Appeal Decision

Appeal Ref: APP/R4408/D/19/3219956

8 Keresforth Hall Road, Kingstone, Barnsley S70 6NF

Project Name: New Build Garden Annex
Drawing Name: Footprint
Drawing No.: 1740.1
Version: 1
Revision: 0
Date: 30.08.2018

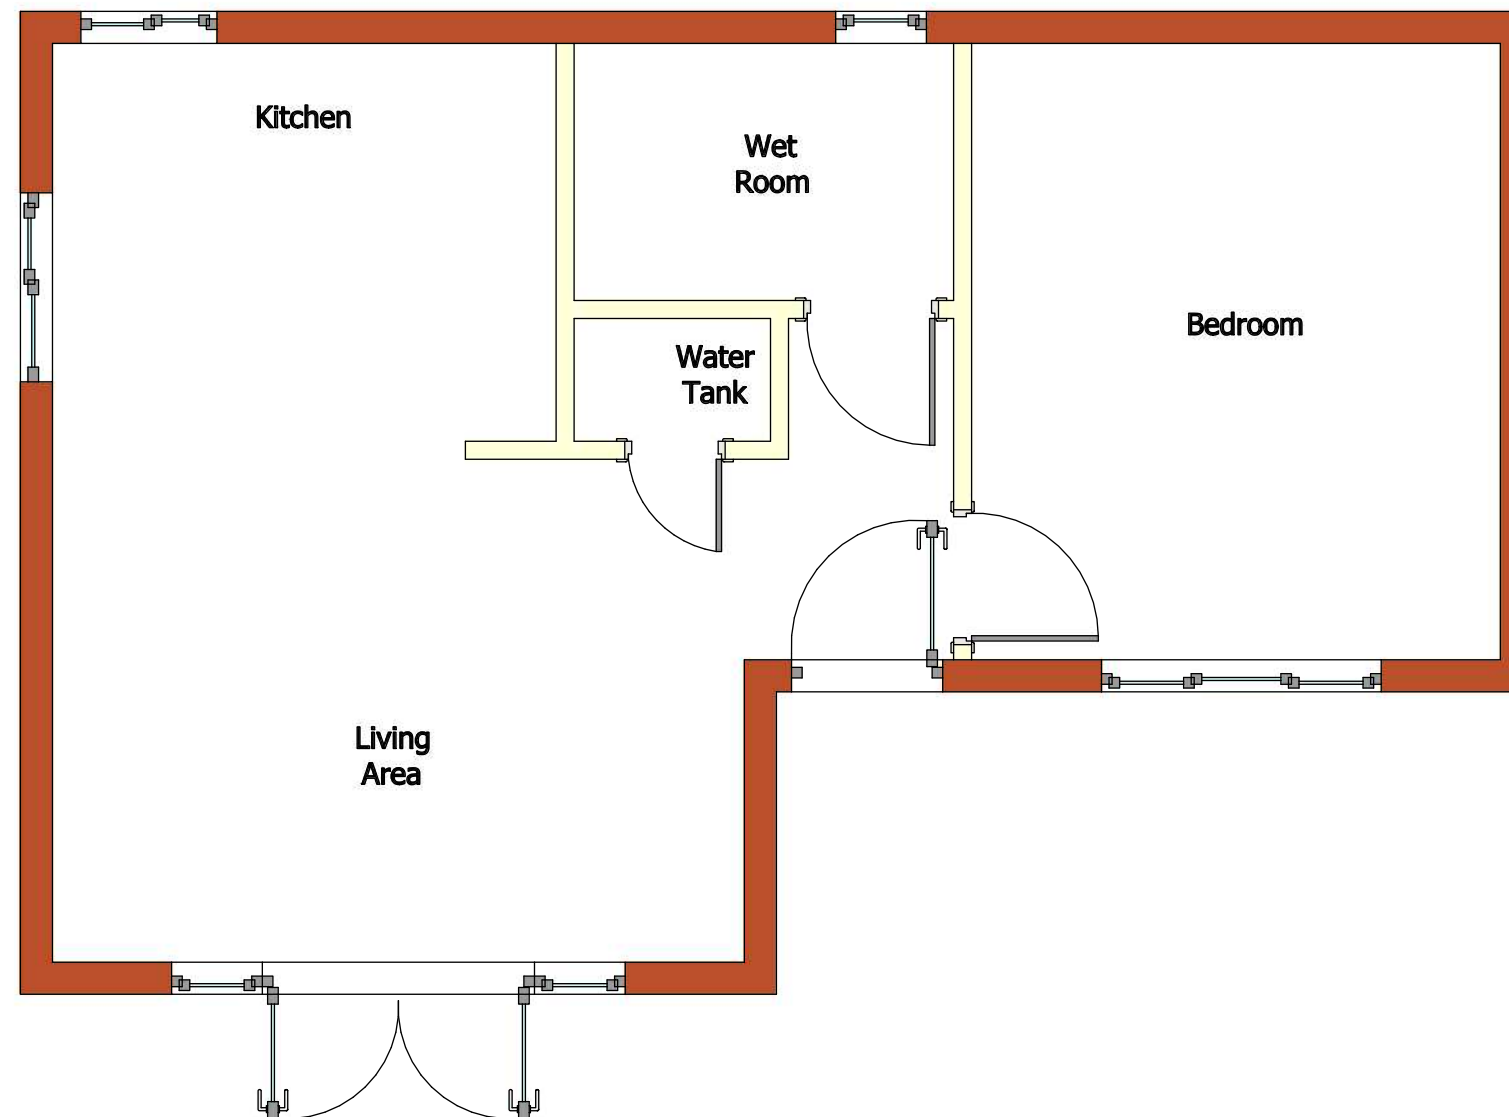
7. The appeal proposal would introduce a detached single storey 'L' shaped outbuilding positioned in the north-west corner of the front garden. It would be constructed in imitation timber weatherboard with a tiled roof and it would provide a bedroom, wet room and kitchen/living area. The application form is clear that planning permission is sought for ancillary residential use associated with the main dwelling.

9. The Council's House Extensions SPD advises that a 'granny annex' should have a close physical relationship with the host dwelling, be single storey and, in all circumstances, it should only have one bedroom and no more than 3 rooms in total. With the exception of the small projecting partition between the kitchen and living area, the layout of the proposal would not be dissimilar to the granny annex at Thurgoland, for which permission was granted by the Council in 2018¹. The kitchen/living area of the proposed outbuilding would be generously proportioned and provide for separate functions, but I am not persuaded that they are two separate rooms given their open plan form. Excluding the space accommodating the water tank, I am therefore satisfied that it would have 3 rooms.
